From:
Sent: 25 May 2026 13:51
To: DC Admin
Cc: louise.bearcroft@gov.uk
Subject: Moor Lane Gomersal Objection to Planning Application 2025/ 92713

What is significant is that from day one the revised plans submitted by PPJ Developments have totally ignored the " Outline Approval " which was for **6 No 3 Bed and 4 No 4 Bed houses**. PPJ submitted plans for

PROPOSED SITE PLAN 1:200 @ A1

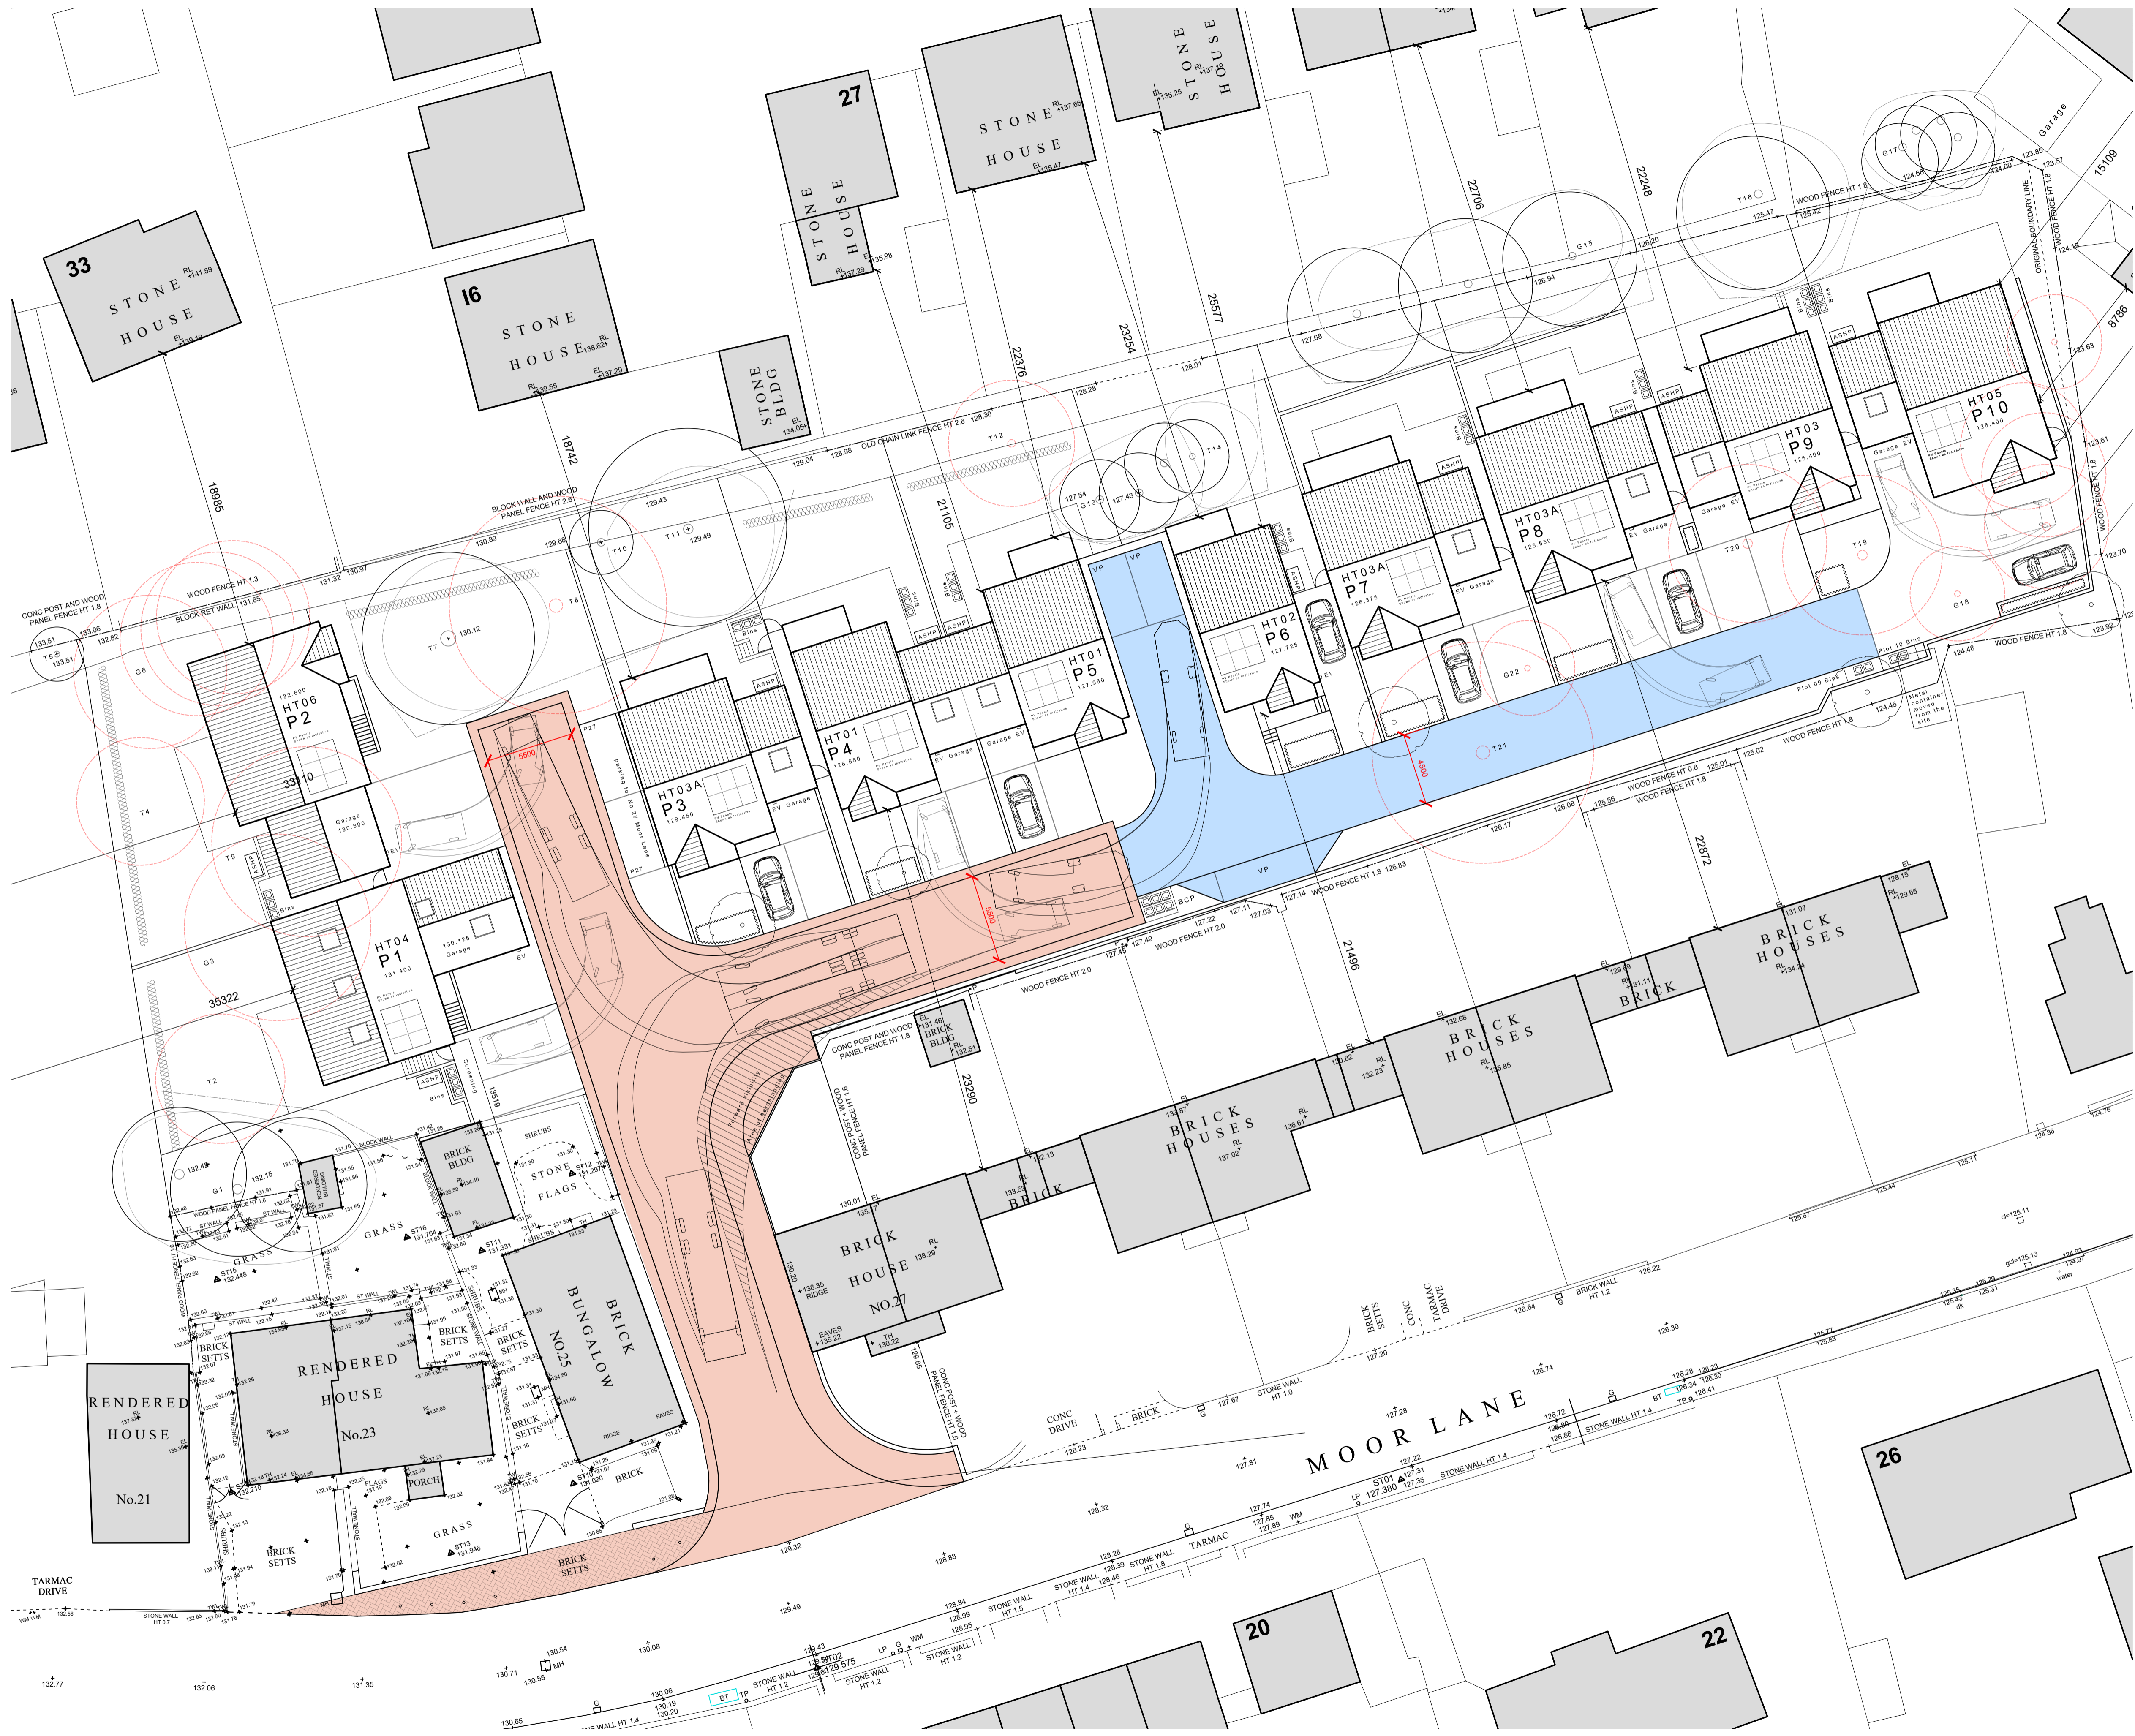
Despite all the objections to the revised plans submitted by PPJ Development's after when they purchased the site from Binks Developments, the only significant alteration to the plans has been the re routing of the (illegal) flood exceedance route. Only minor amendments have been made to the plans, such as bin collection points, hedge positions, road widths, and visitor parking alterations which are quite insignificant in the grand scheme of things.

6 No 3 Bed, 2 No 4 Bed and 2 No 5 Bed houses, one being 3 storey.

To substitute two of the 4 bed houses for two 5 bed houses can only increase the the "**cramped and invasive form of the development**"

The 5 bedroom 3 storey house is shown at the entrance to the development which will overlook Peel House (listed) and the other 5 bedroom house is shown at the bottom of the site and will overlook 21 Summerdale and the roof line will be approximately 2.00 metres higher.
